**WEST SUSSEX COUNTY COUNCIL
STRATEGIC PLANNING CONSULTATION**

DATE: 29/03/2017

SUBJECT: AL/111/16/OUT-Outline application with some matters reserved for 57No. units with public open space & affordable housing. This application is a Departure from the Development Plan.

Land East of, Orchard Gardens, Aldingbourne, West Sussex

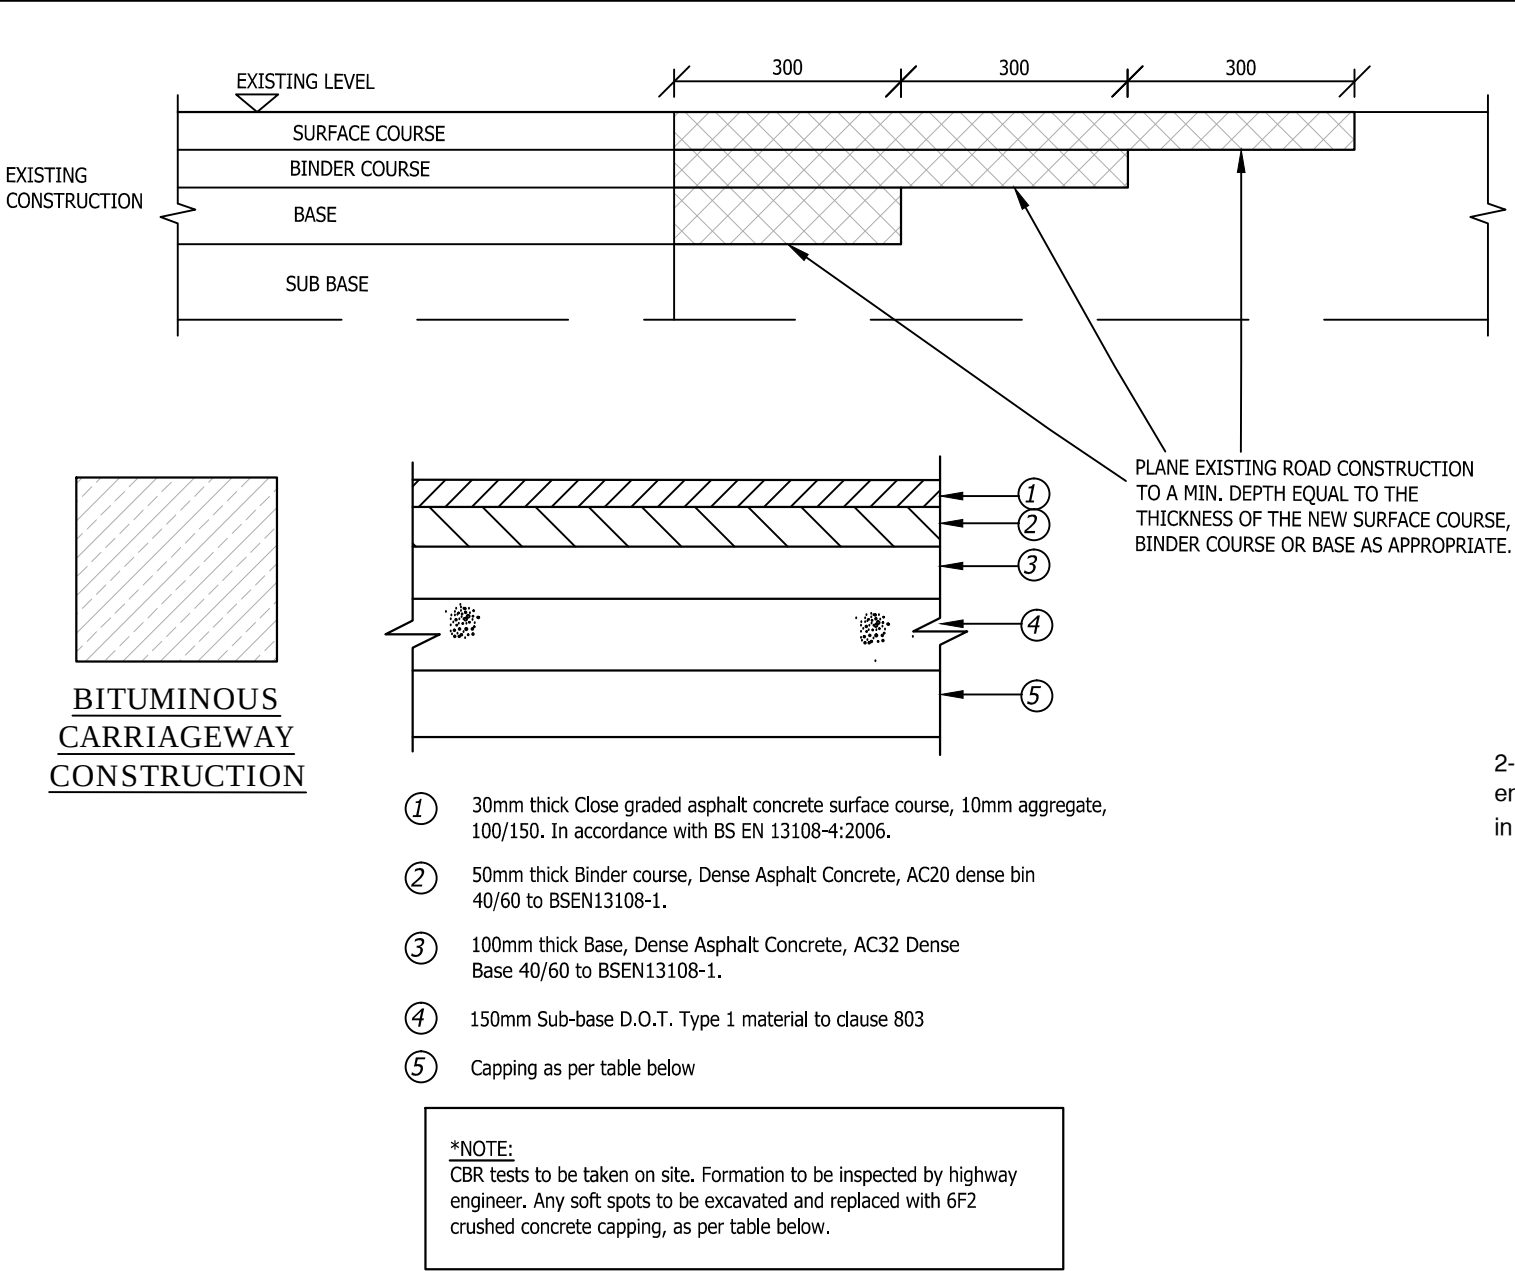
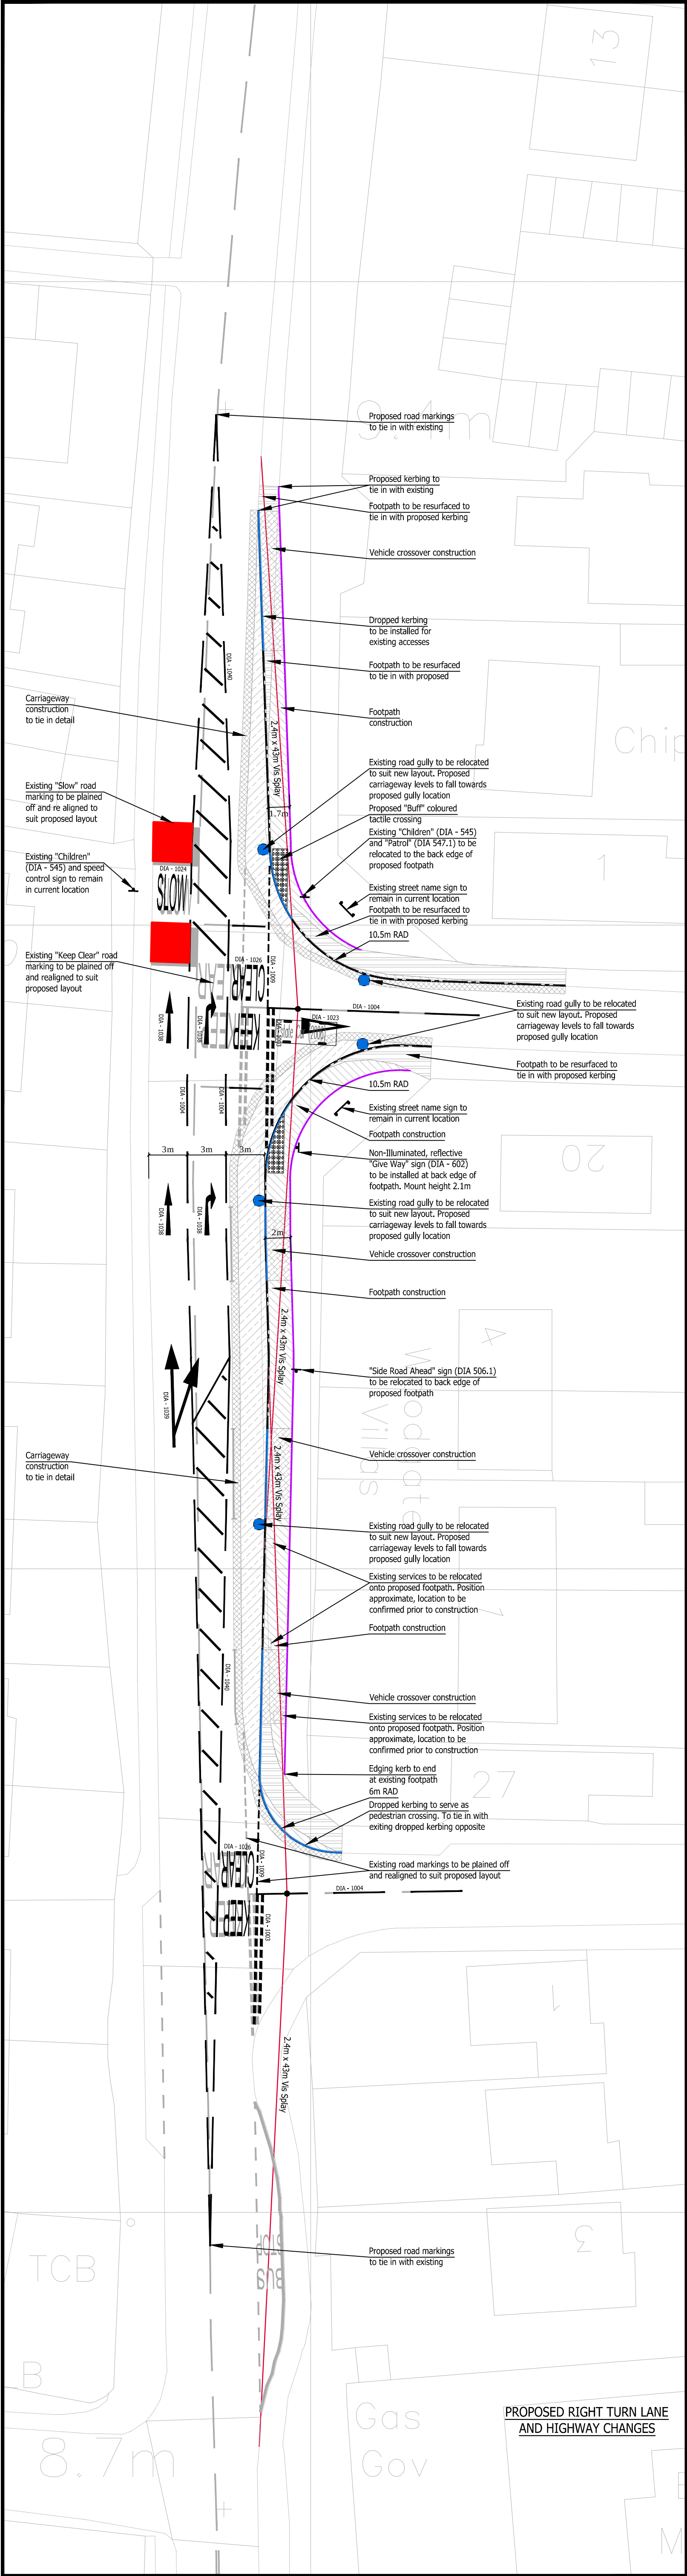
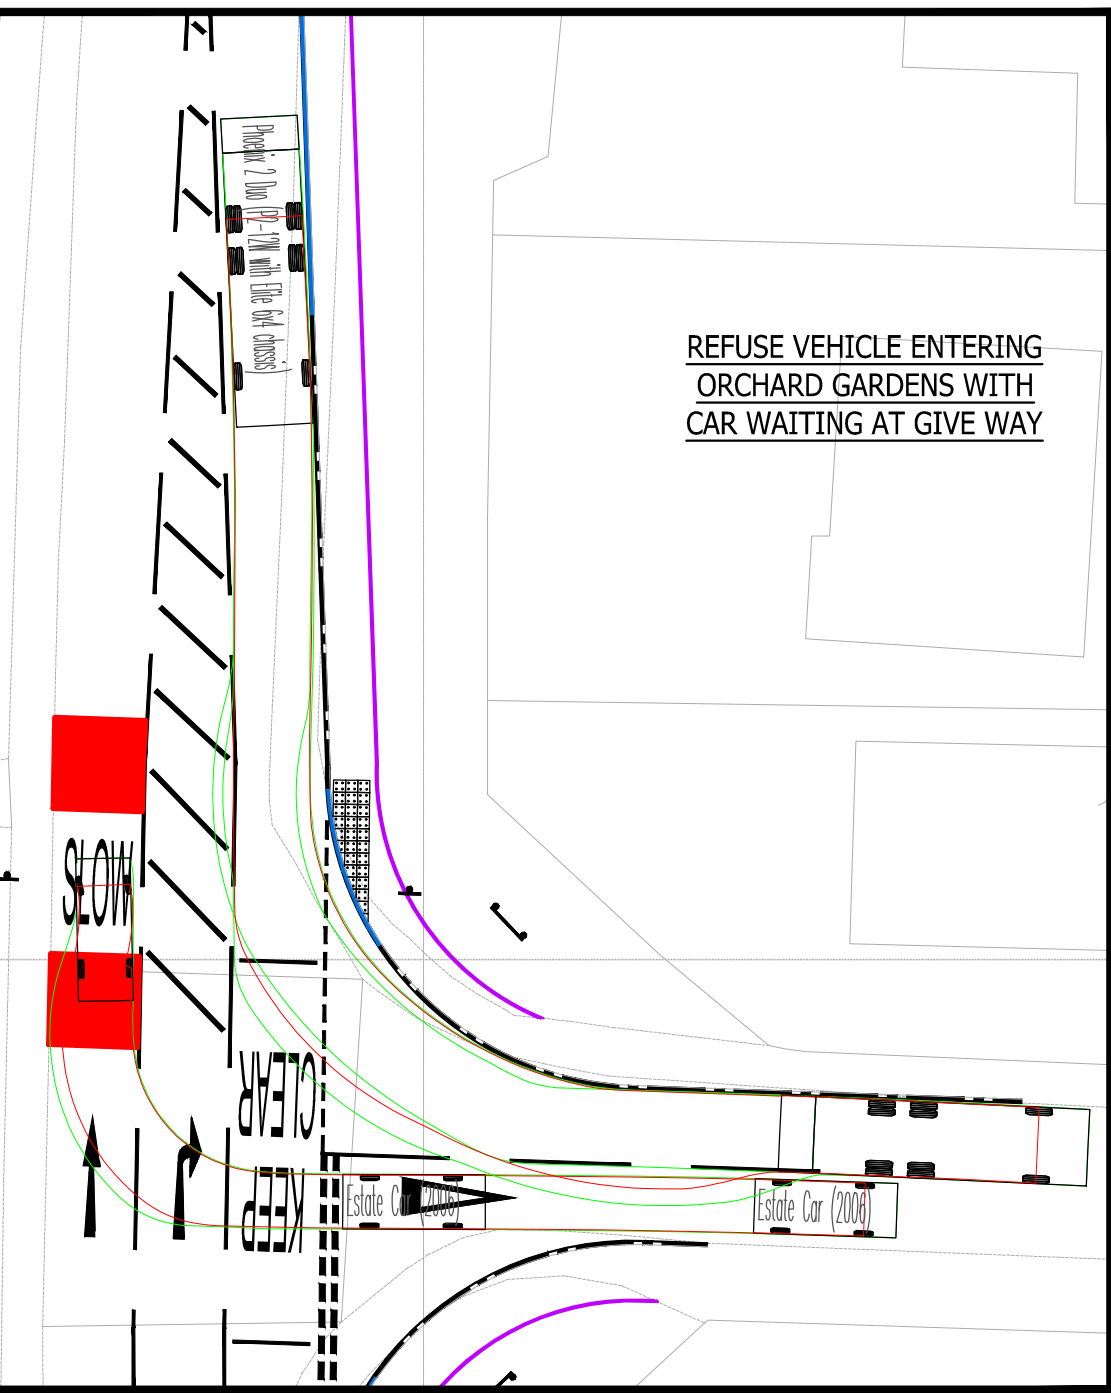
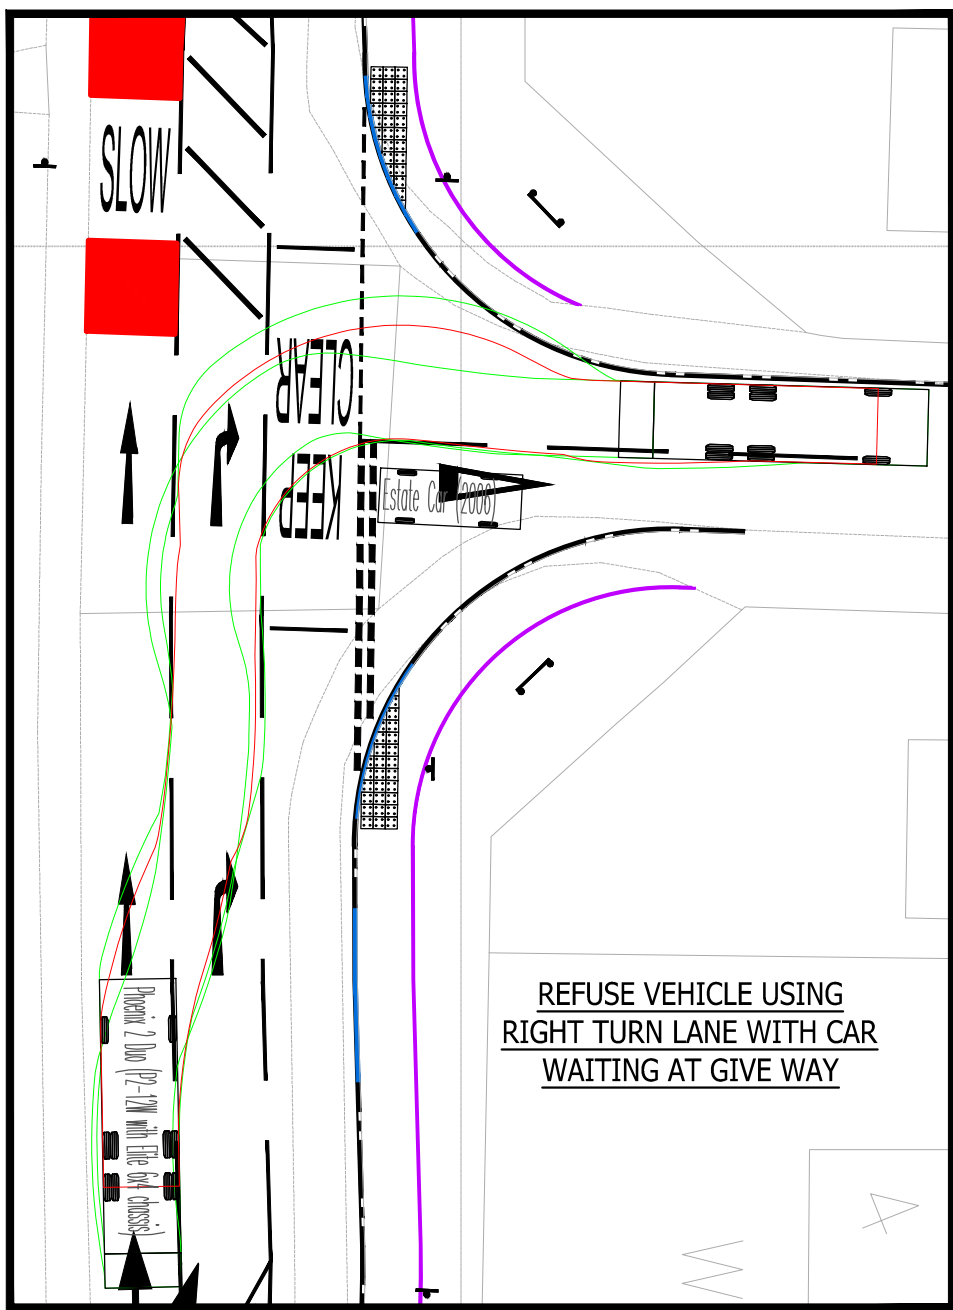
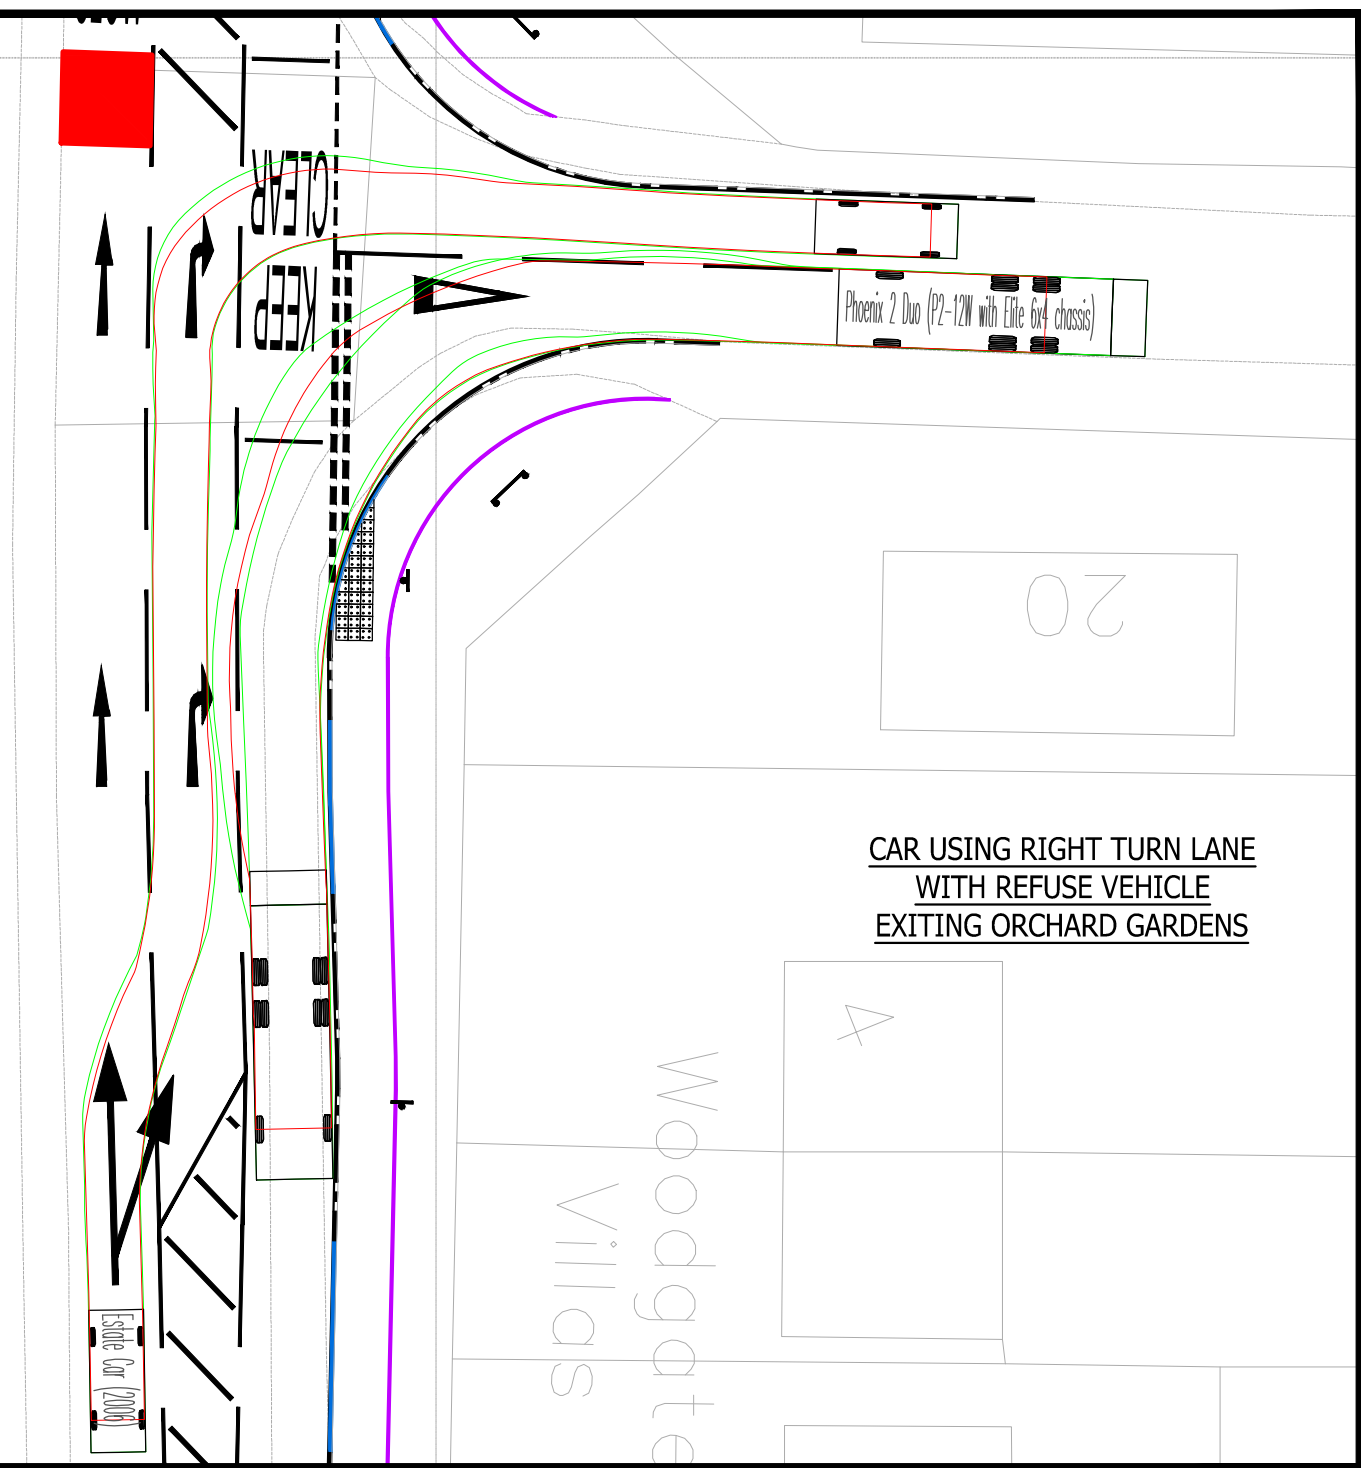
The LHA has held discussions with the applicants Transport Consultant on the areas forming part of the objections to the application consultation from November 2016, namely the integration with the Hook Lane RTL and the technical details of the proposed RTL. Following this the LHA are now satisfied with the proposed RTL based on the changes that have been made in accordance with drawing number 5919/100 Rev D, this includes:

- **Pedestrian Links**-Where the pedestrian crossing is located, the drawing has been modified to demonstrate the access points of the adjacent properties on the road to the east to ensure that there is no conflict.

- **Swept Path Diagrams and RTL**-The RTL has been widened to circa 3.5 metres and the accompanying swept path has been modified to show that it does not overhang onto the A29.

- **Alignment of RTL** - The southbound carriageway taper has been adjusted to allow for a 1 in 20 tapers.
- **Bus Shelter**-The existing bus shelter has been positioned accordingly to ensure it does not infringe on visibility immediately to the south. The shelter is of a cantilever design and we are satisfied with a cantilever wooden shelter. It is advised that the applicant liaises with the applicant for the Hook lane RTL on its re-location.

- **Visibility Splays at Junction with Orchard Gardens**-We have assessed the proposals against TD42/95 'Geometric Design of Major/Minor Priority Junctions'. The 2.4 by 43 metre splay proposed at the junction of Orchard Gardens is a departure from standards. MfS states that full visibility is not required in low speed urban environments, this proposal is not considered to meet this criteria. In difficult circumstances, the 'x' distance may be taken as a relaxation from 9.0m to 4.5m for lightly trafficked simple junctions, and in exceptionally difficult circumstances, to 2.4m back from the nearer edge of the major road running carriageway. In this instance we would be satisfied with a 3.0 metre 'X' distance by 43 metre visibility splay as a compromise. This has been agreed, but not demonstrated on this particular plan. We would request that the plan is modified to show the previously agreed 3.0 by 43 metre 'X' distance. The land in question for the splay would appear to within publicly maintainable highway.

Having considered the above and on the basis that the drawing is updated to include the 3.0 metre 'X' distance the LHA does not consider that the proposal would have 'severe' impact on the operation of the highway network, therefore is not contrary to the National Planning Policy Framework (para 32), and that there are no transport grounds to resist the proposal.

No part of the development shall be first occupied until visibility splays of 3.0 metres by 43 metres have been provided at the existing site junction onto Westergate Street in accordance with plans and details submitted to and approved in writing by the Local Planning Authority. Once provided the splays shall thereafter be maintained and kept free of all obstructions over a height of 0.6 metre above adjoining carriageway level or as otherwise agreed.
